January 5, 2010

Re: 546 Seashore Avenue, Peaks Island – 086 A015 – IR-1 – build addition – permit #09-1220

KOUTALIDIS HOUSE
546 SEASHORE AVE
PEAKS ISLAND,
SCALE: 1" = 20'-0"

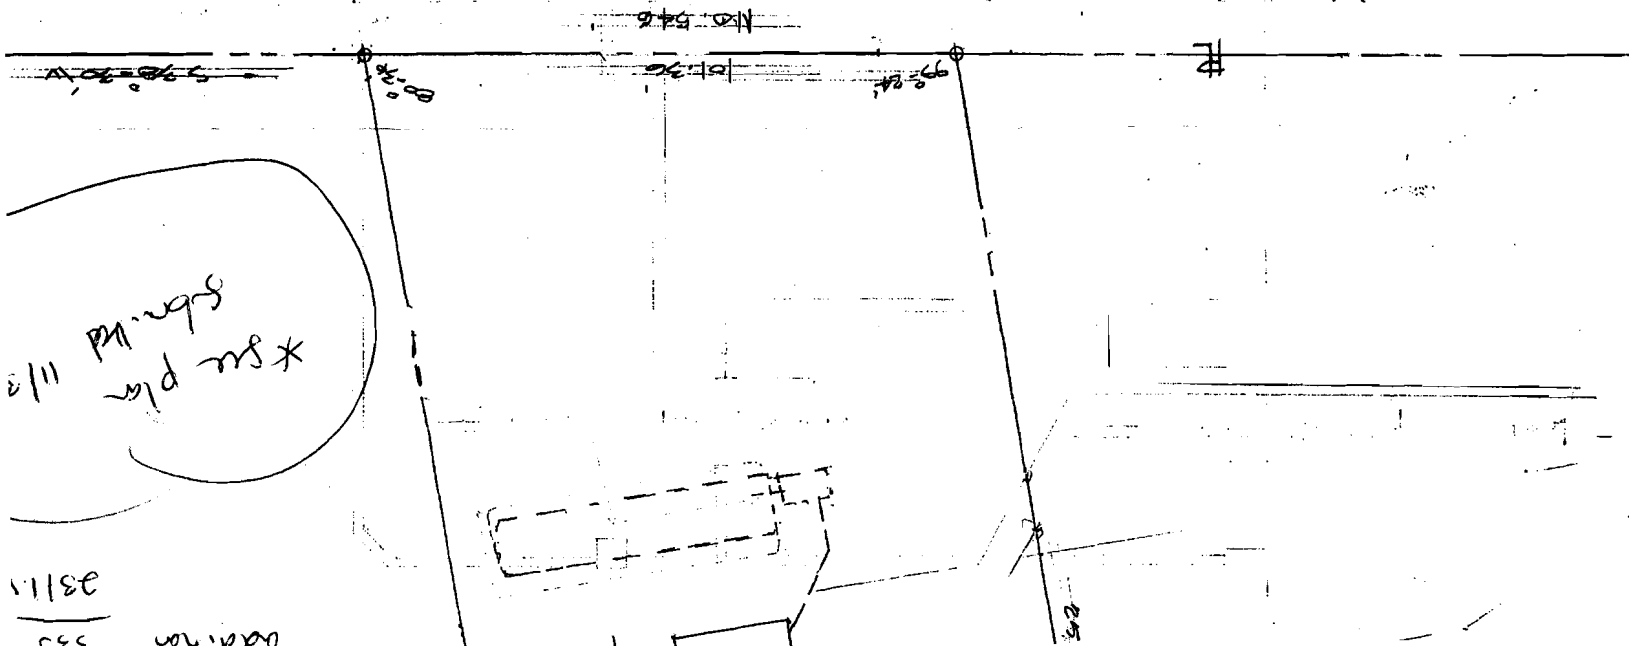
In order to complete the zoning review on your application, I need some more information. I need a revised plot plan that is either to scale or dimensioned that shows exactly what is existing now and what is being added with this permit. I need this to determine whether lot coverage is being met.
